Date: 08-Sep-2023
Our Ref: 2023/92486

Non material amendment to previous permission 2022/90206 for erection of agricultural workers dwelling

Carter Plantation Farm, Thick Hollins Road, Meltham, Holmfirth, HD9 3XD

Application Number: 2023/92486

front elevation (east) - 1:100

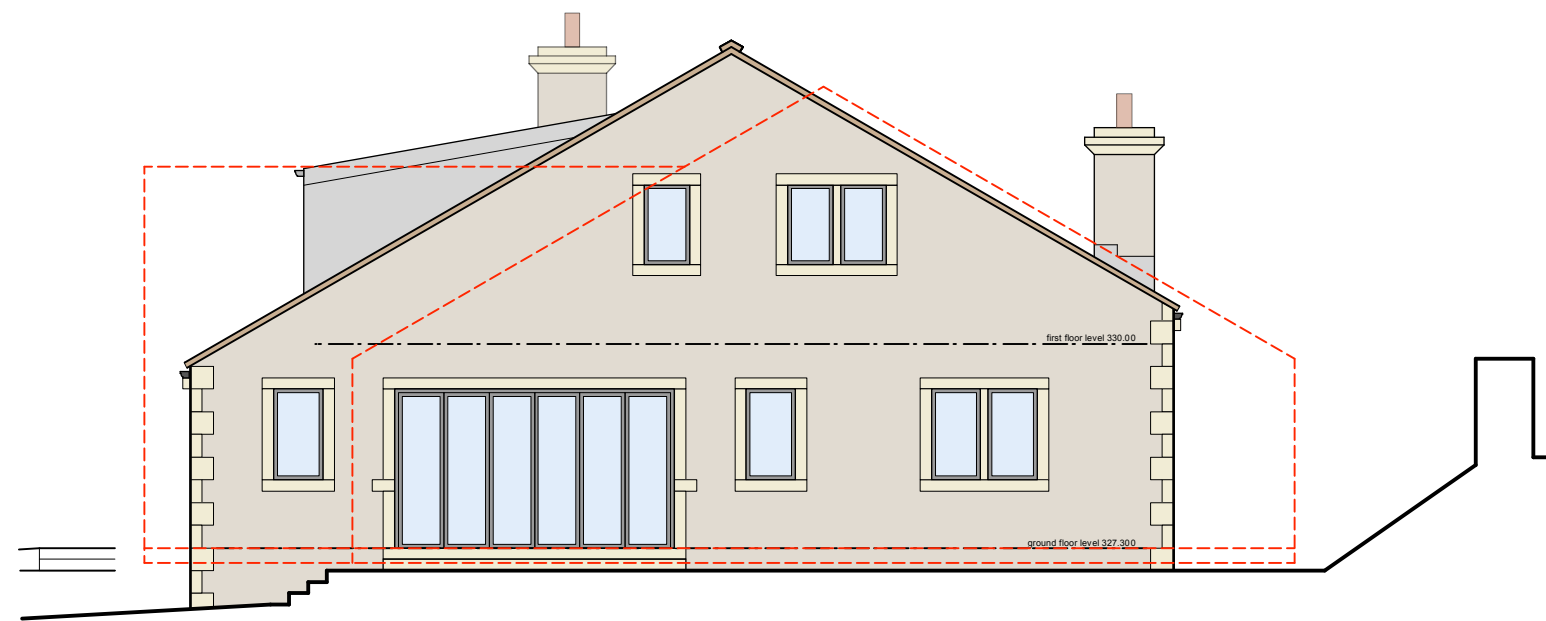
- east elevation – additional chimney,
- west elevation – reposition door, window and chimney,
- south elevation – reduce width of window,

I confirm that the alterations are acceptable and may be considered as a non-material amendment to the approved drawings. It should be noted that this letter relates only to the non-material amendment sought and it is not a re-issue of the original planning permission. The two documents should be read together and as such, all conditions imposed on the original granting of planning permission apply to the proposal as now amended. A copy of this letter and the amended plans will be retained on the public record of approved documents.
